**Consultation Response from KC,
Trees**

2024/92779 land at Providence Street, Earlsheaton, Dewsbury, WF12 8HZ

Outline application for residential development

Date Responded: 24/03/2026

DRAWING:
ILLUSTRATIVE MASTERPLAN

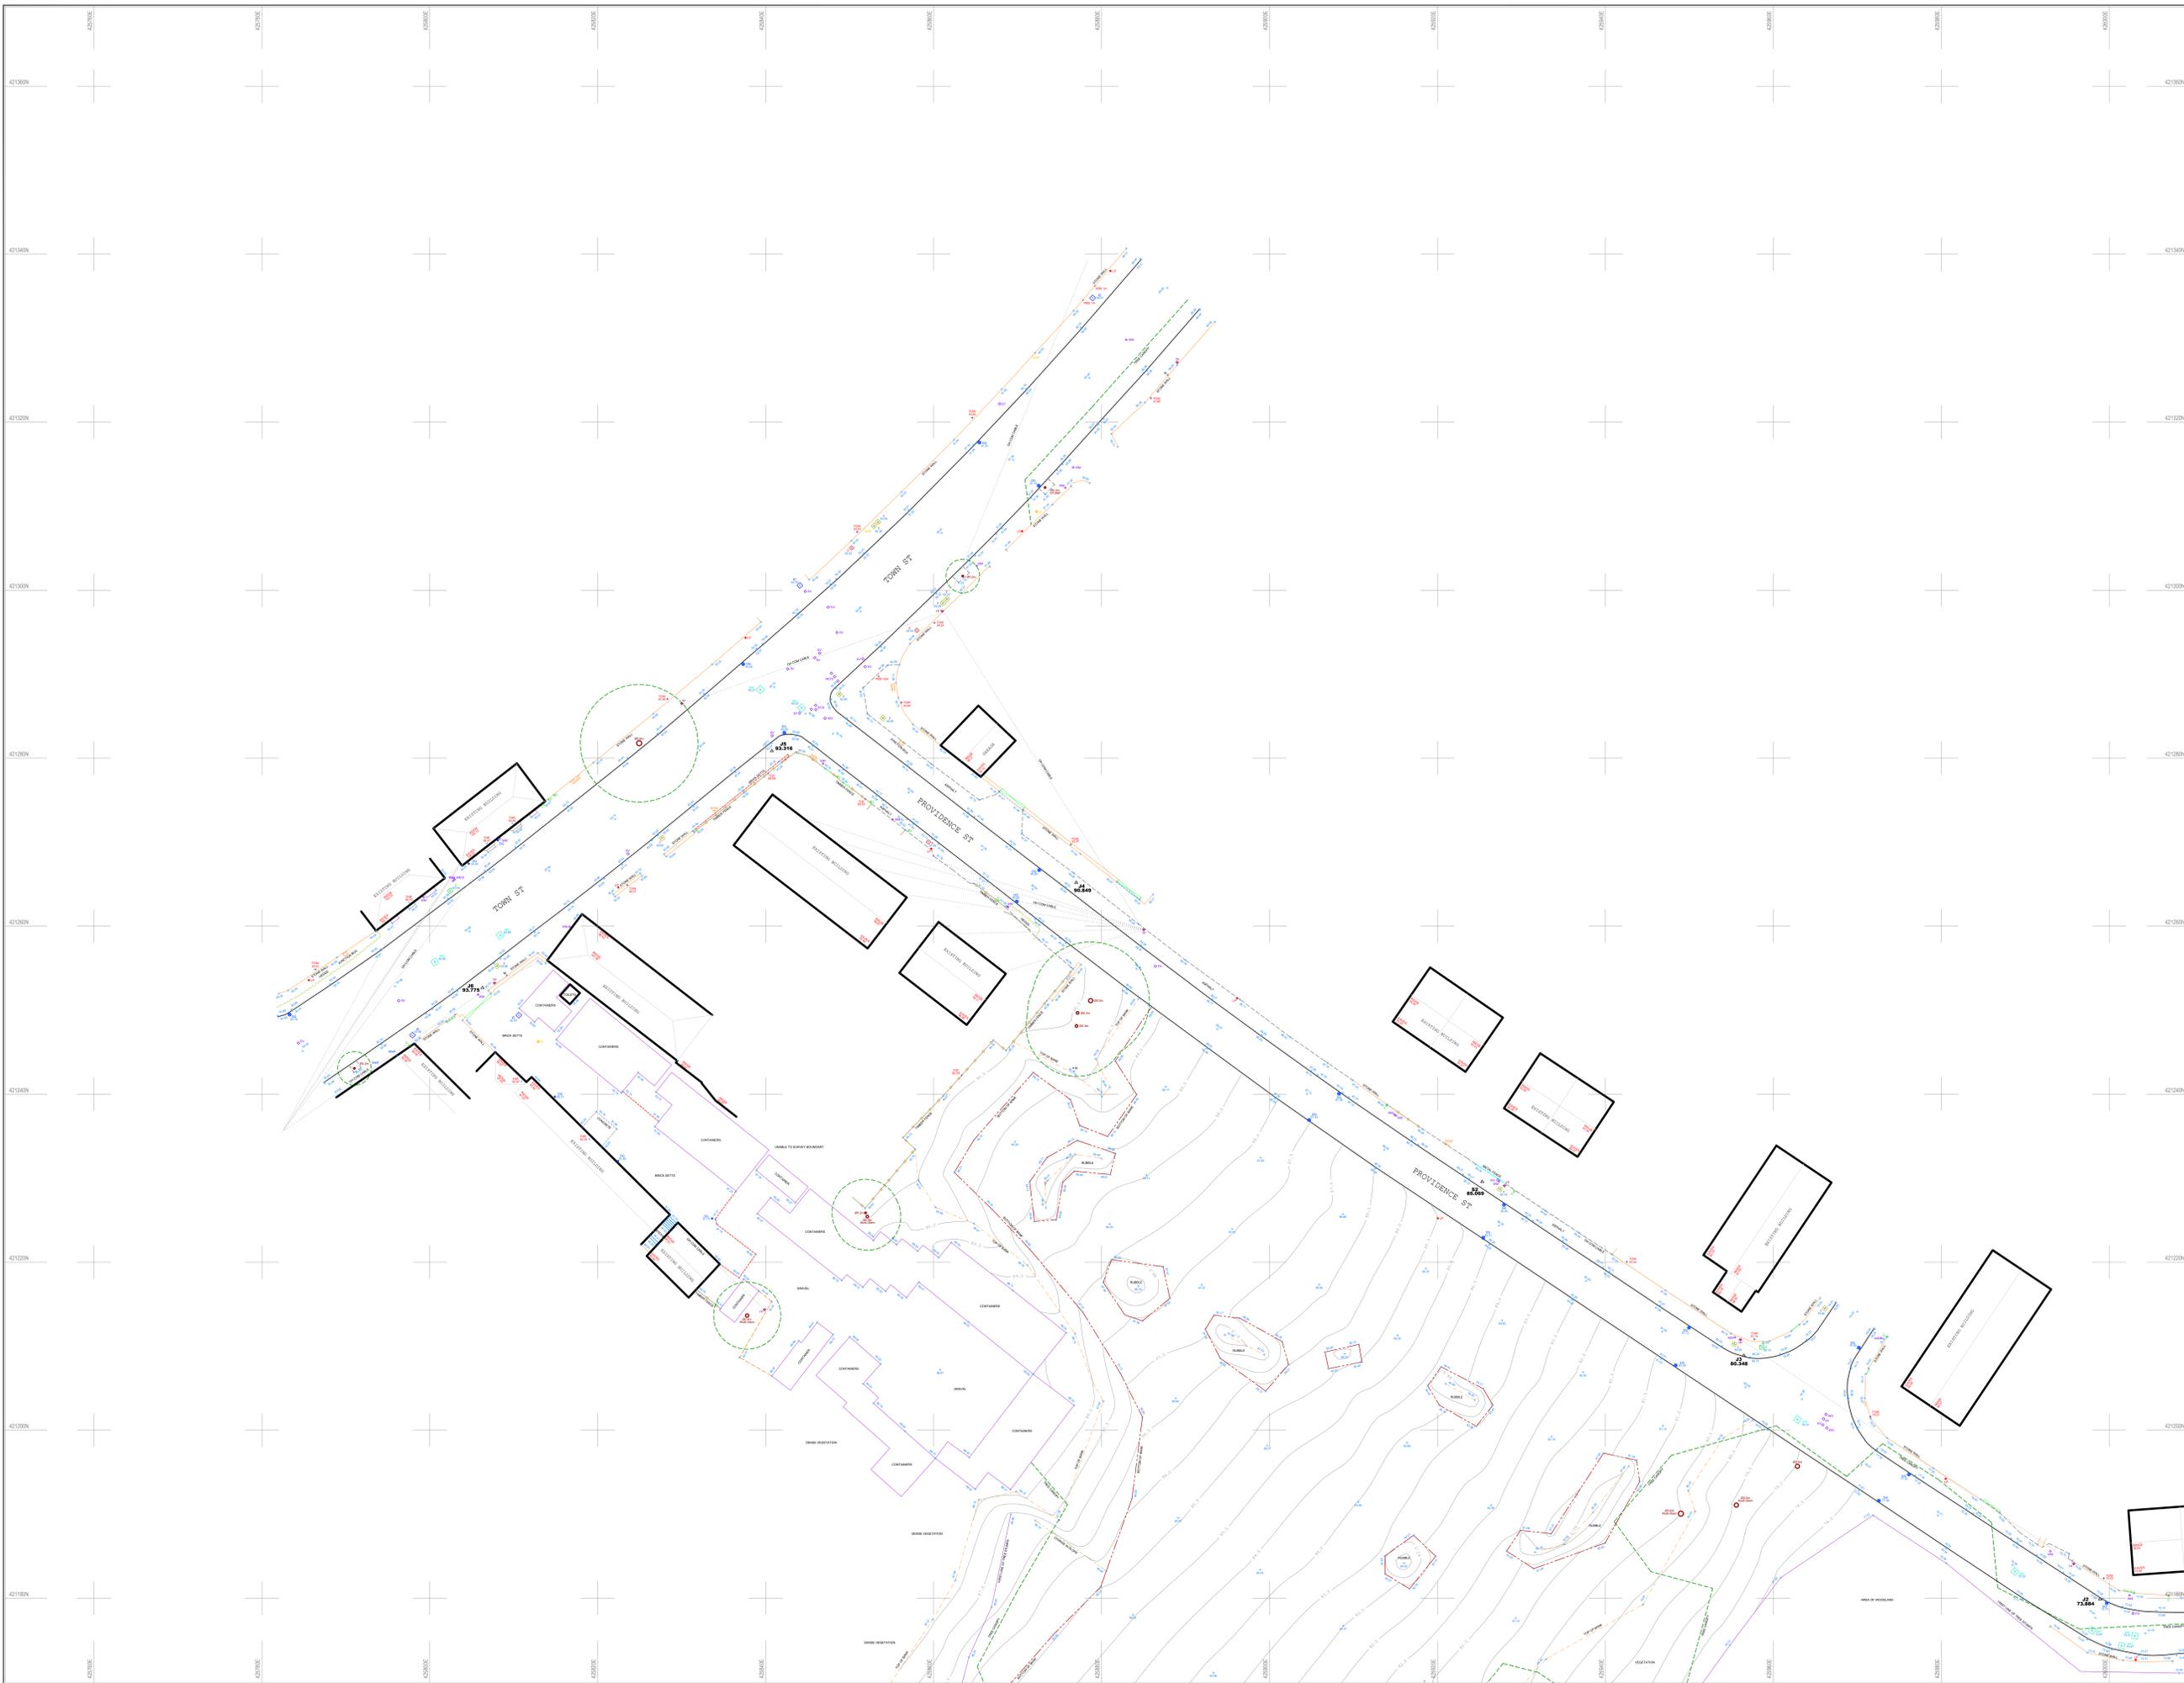
The new proposals include no meaningful changes to the outline scheme. KC Trees' previous comments have been addressed. The proposed tree planting is largely tokenistic and the proposed planting locations are unsustainable, as previously discussed.

Tree planting proposals must consider the mature size of the planted trees and allow adequate space between them and any proposed structures. Issues of nuisance which might also lead to the removal of trees must also be avoided by carefully selecting species and choosing sustainable planting locations to ensure a harmonious relationship between the landscaping proposals, proposed structures and future occupants.

Five new trees are proposed to be planted along the frontage of Providence Street, to mitigate loss of the removed tree belt. These would offer some amenity value and screening into the site. However

realistically, the space allowed between the highway and the buildings is limited within the proposals and these trees would be planted in-between driveways, which would also limit the available rooting area. It is unlikely that there is adequate space for even smaller tree species, such as rowan or birch to mature in these locations without conflict or removal by residents.

Instead, we would expect to see a generous verge on the frontage of Providence Street to accommodate tree planting to replace the tree belt which has been removed without the appropriate consent. There must be ample space to accommodate larger tree species, which would capture more carbon, live longer and offer more in the way of ecosystem services and habitat value. Therefore, the design cannot include plots directly off Providence Street.

The illustrative masterplan shows tree planting throughout the development located beside driveways, which again, would constitute smaller species, which are unlikely to be retained due to foreseeable conflicts with future residents. Many of these are sited south of proposed buildings and would cast shadow on the homes. Tree planting locations must be sustainable to reasonably ensure future tree cover within the site.

- AMS and Tree Protection Plan.
- 10-year woodland management plan, detailing replanting, management interventions and woodland enhancements.
- A detailed planting scheme, including sustainable tree planting locations with appropriate species and a landscape management plan to outline how new trees will be maintained.
- KC trees will amend the TPO 02/24 to include the agreed landscaping scheme and enhanced woodland.
